MEMORANDUM

Date: August 31, 2018
To: Gabe Sevigny, Planning, El Paso County Planning and Community Development
From: Tamara Baxter, Project Manager – N.E.S. Inc.
Subject: PPR-18-017 First Review – Mountain Splendor Services

SITE DEVELOPMENT PLAN

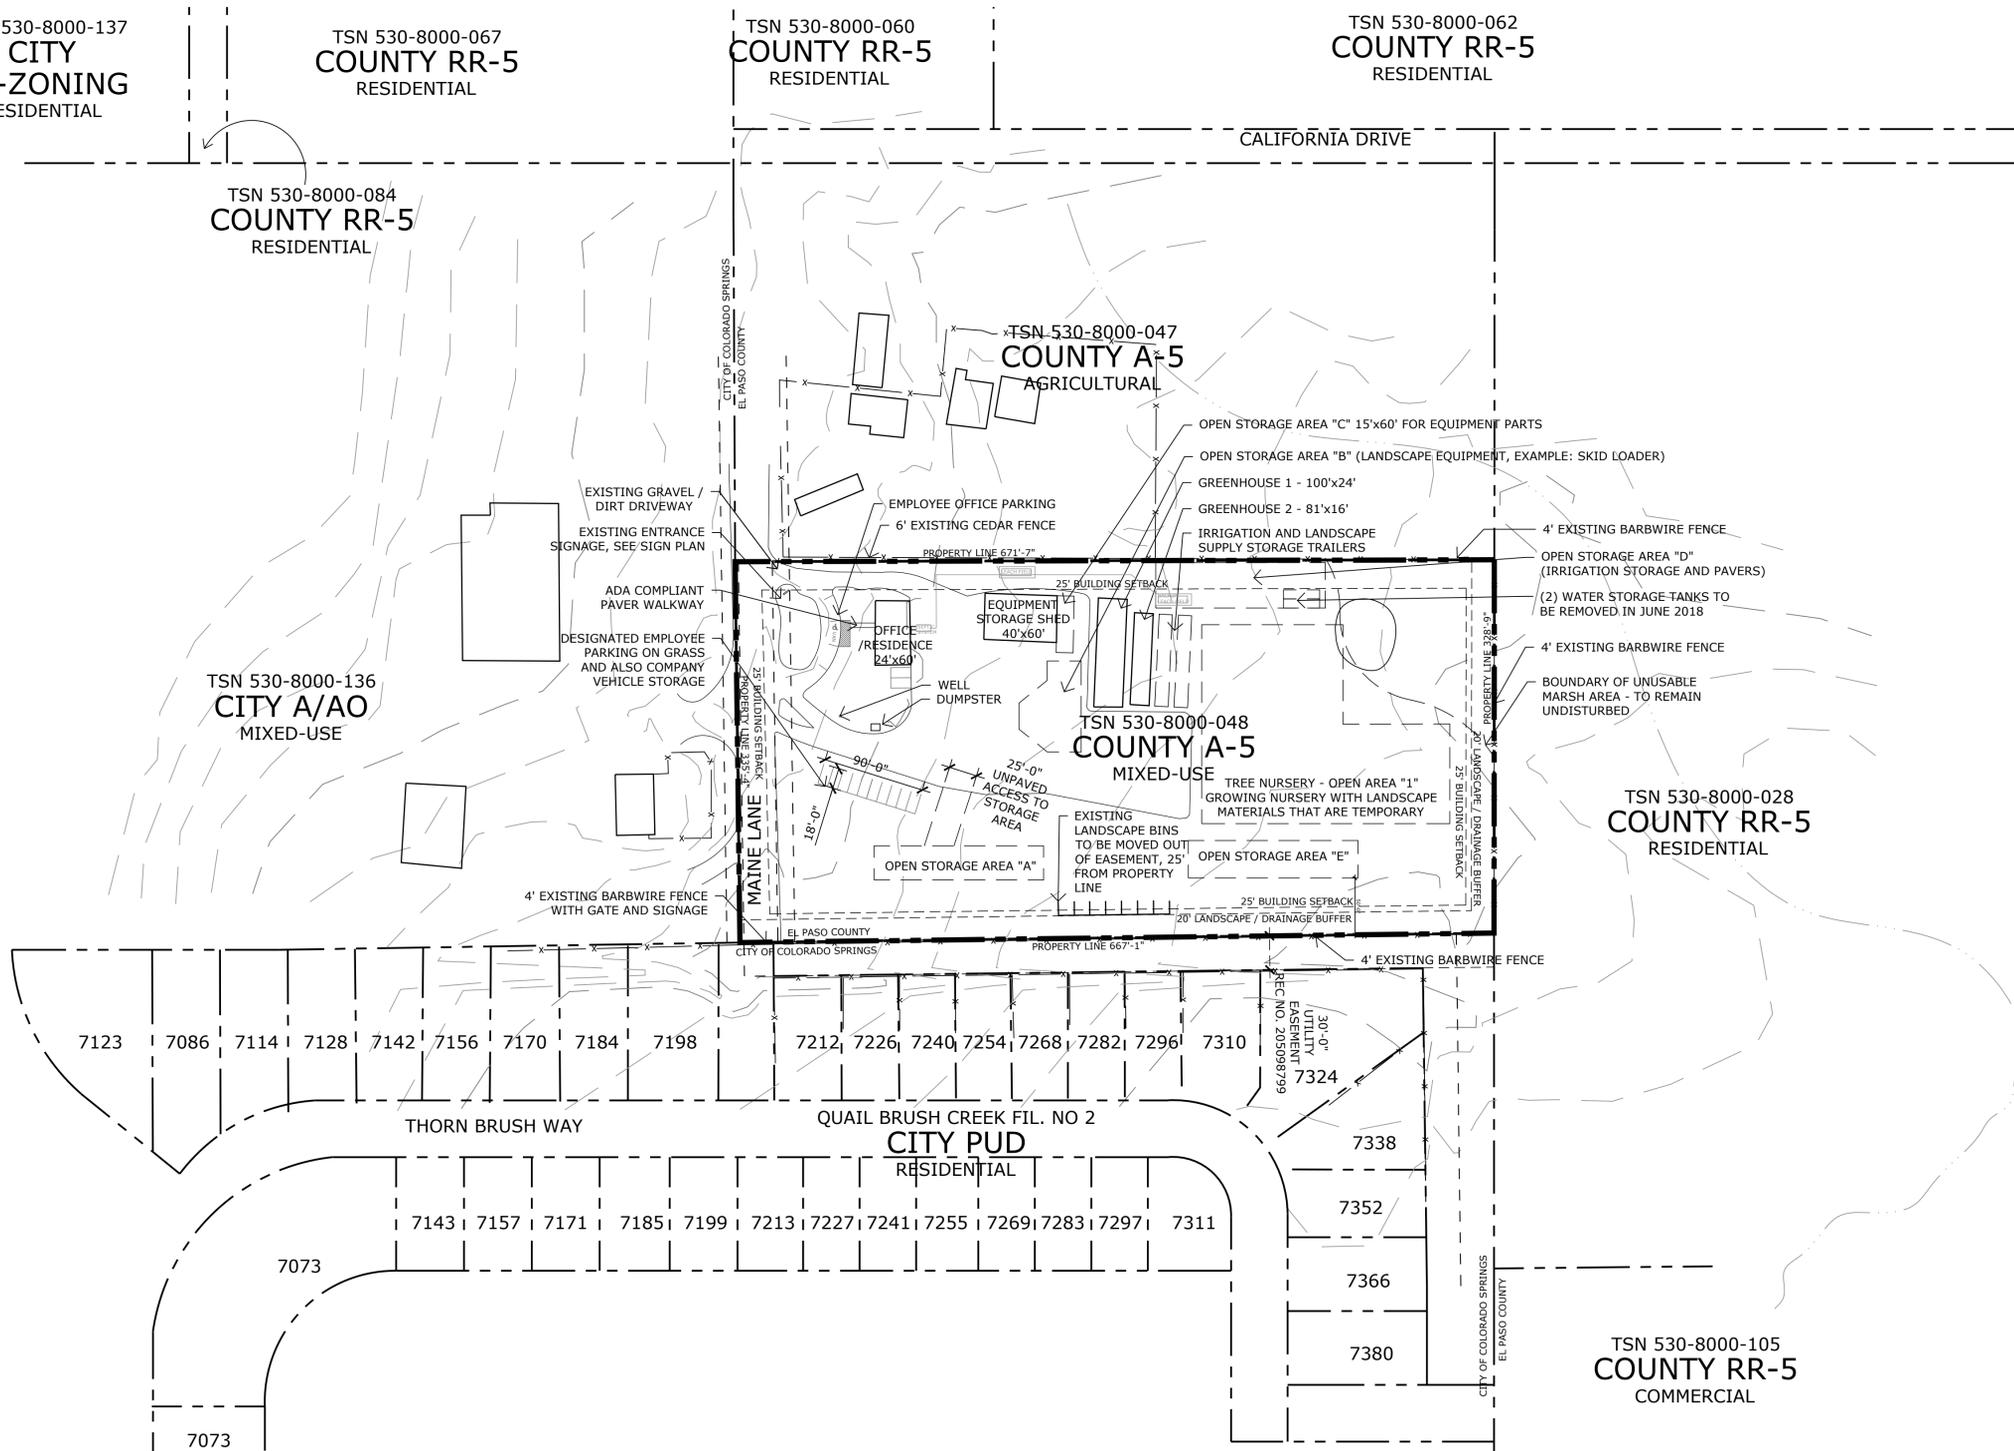
- The permitted and approved onsite wastewater treatment system (OWTS) was installed in 1988 and sized for a 3 bedroom house. The soil treatment area (STA) is located south and east of the house/office, and is not identified on the site plan. A map of the OWTS components is available on the El Paso County Assessor's Office website:
<http://www.land.elpasoco.com/default.aspx>

- The existing primary STA must be located, and traffic control measures must be taken to protect it from compaction by vehicular traffic. There must be an equally sized secondary STA site identified and protected from compaction that meets the 100' setback from the existing well. This site is required in the event that the primary site were to require repair or replacement.

Response: The client has been working with Watson Rooter to verify the location of the existing septic system, based on the Individual Sewage Disposal Inspection Form dated November 22, 1988, pulled from the El Paso County Assessor's Office, and to address the comments from the El Paso County Public Health (EPCHP).

The Watson Rooter has placed a camera in the septic system to determine size and location. The existing septic system will not be relocated, however, the Owner will institute traffic control measures in the location of the existing septic system. The site plan delineates the location of the existing septic system and leach field. A tentative location of a secondary soil treatment area (STA) has delineated on the site plan should the existing STA require repair or replacement. All work related to the septic system and leach field will be completed by the end of September 2018.

1 LANDSCAPE PLAN

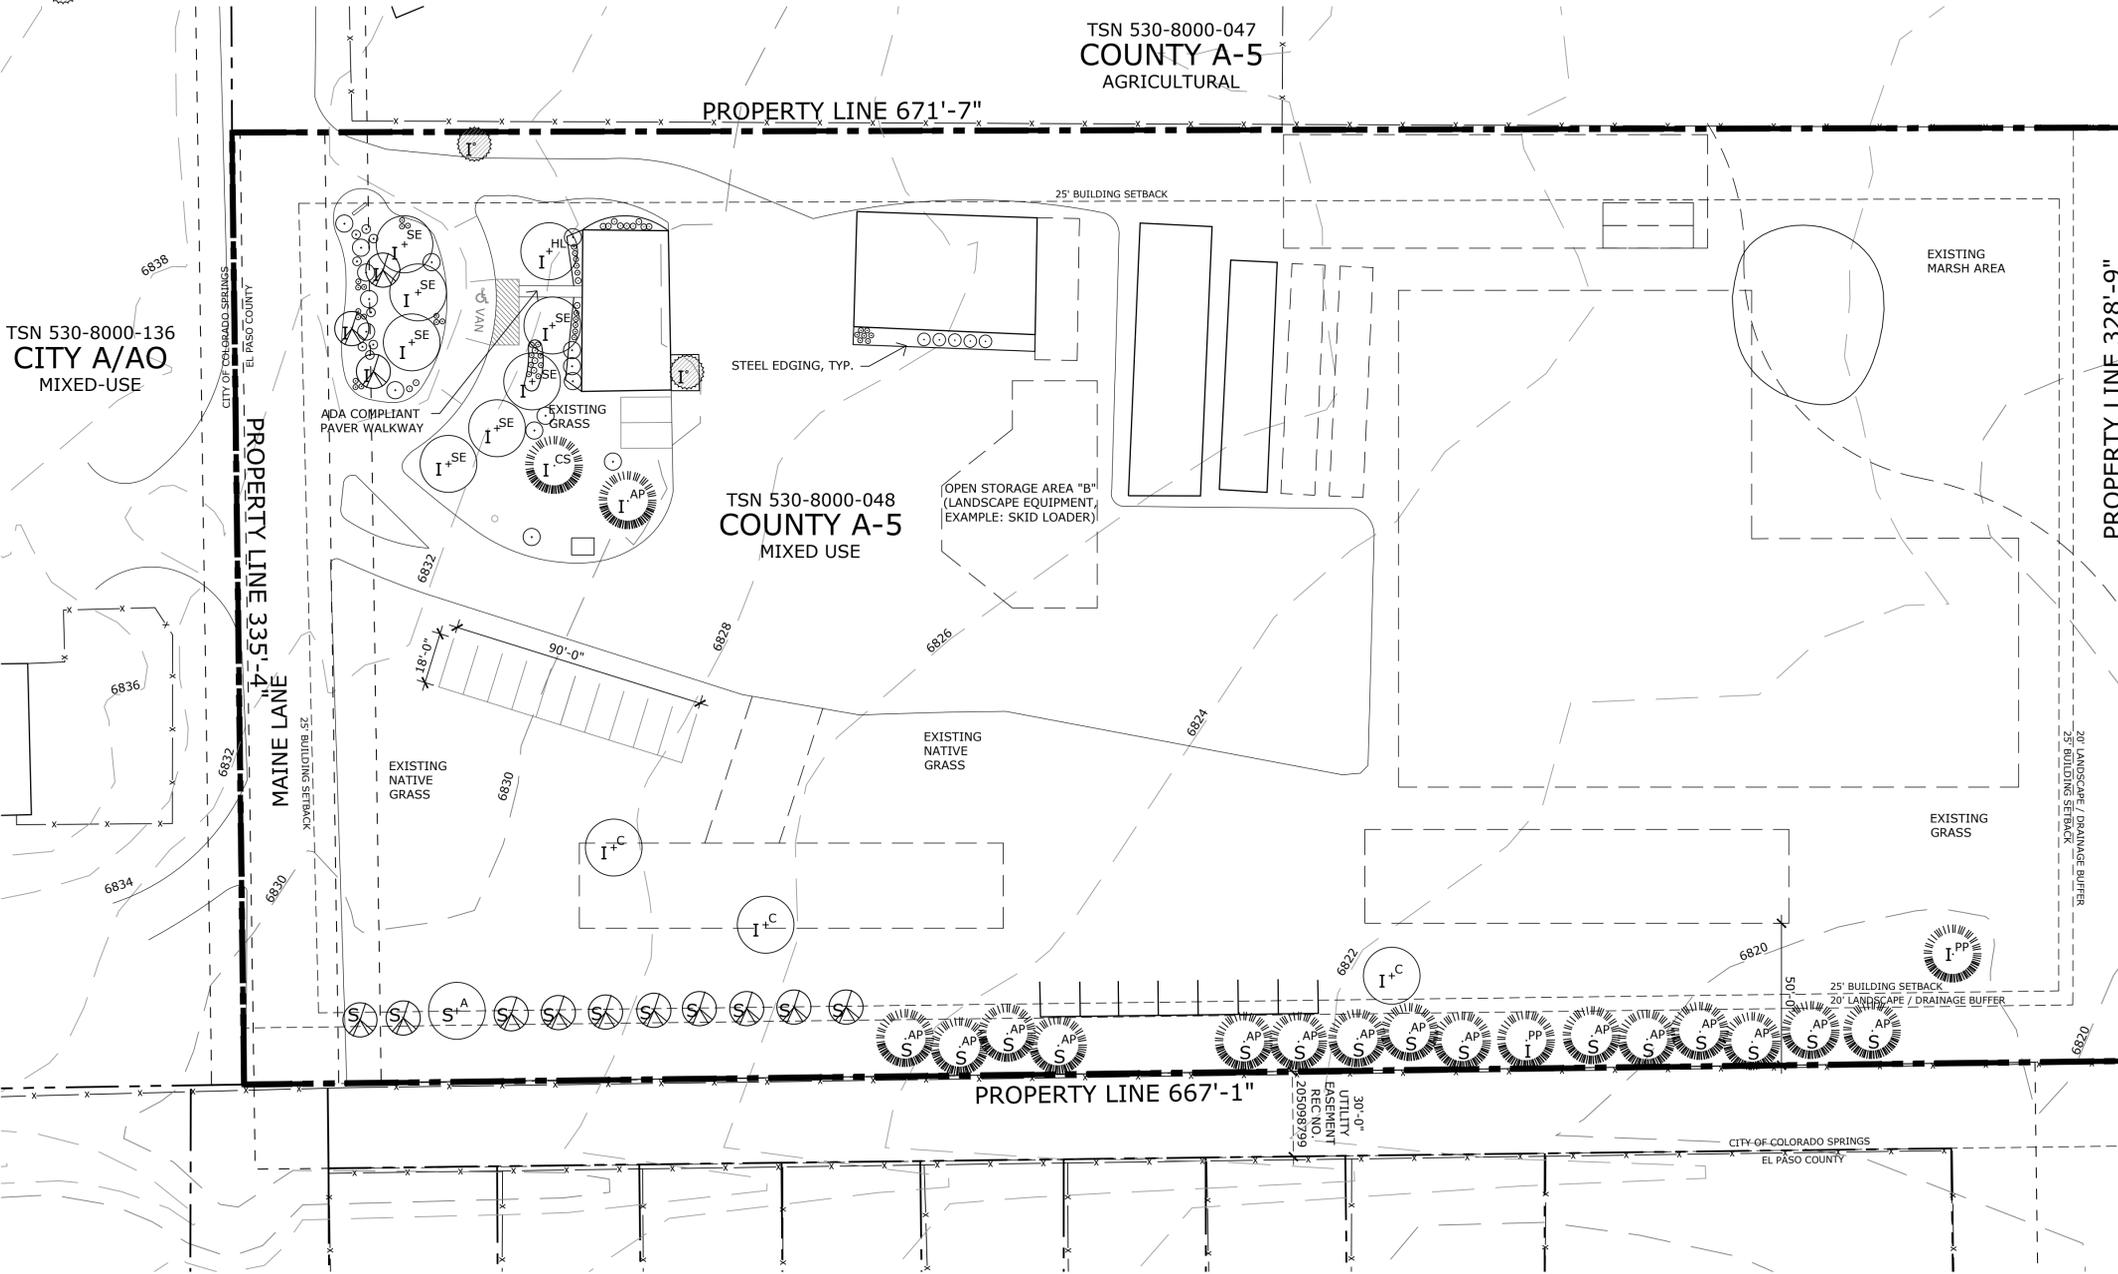
- Landscaping must be installed prior to Certificate of Occupancy, except for the section outlined as a condition of the Variance of Use approval

Response: A Landscape Plan has been attached. All necessary trees and shrubs are already planted on-site. No additional trees or shrubs are necessary.

1 EQUIPMENT STORAGE SHED FLOOR PLAN

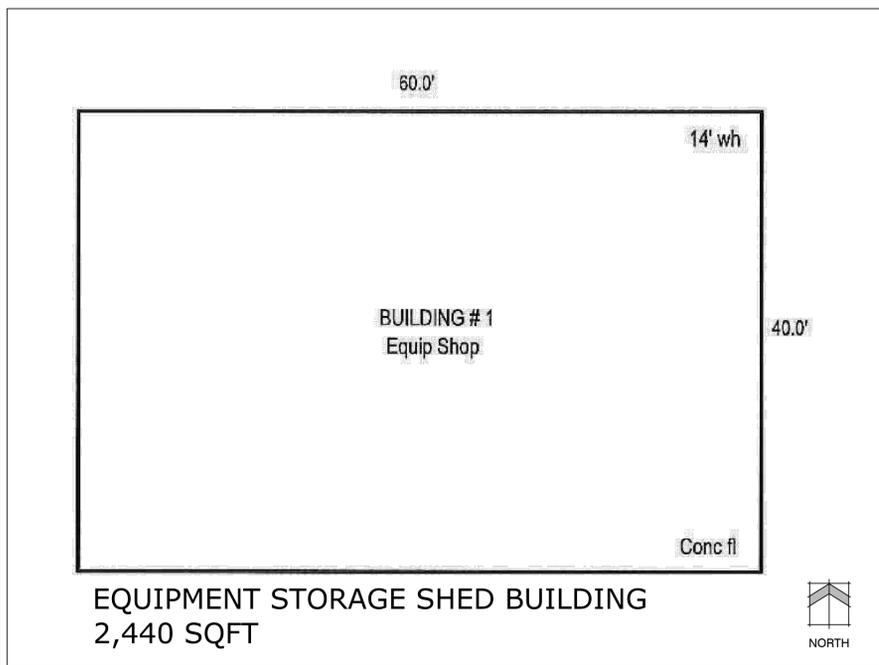
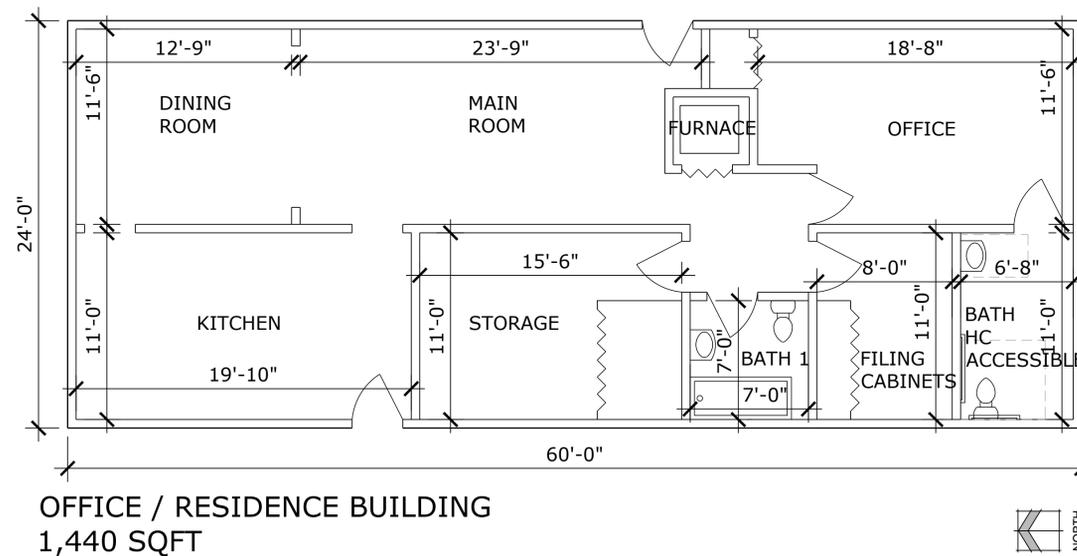
- 1. Approved Driveway Access Permit Waiver has been attached.**
- 2. Actual building height for the office building and the Pole Barn have been provided on the Elevation Plans.**
- 3. The Owner submitted a well permit application to the State of Colorado Water Resource Division for the change of use (attached). The Owner is working with Petrock and Fendel P.C., Water Attorneys, to resolved well permit changes in response to the Colorado Division of Water Resources comments.**
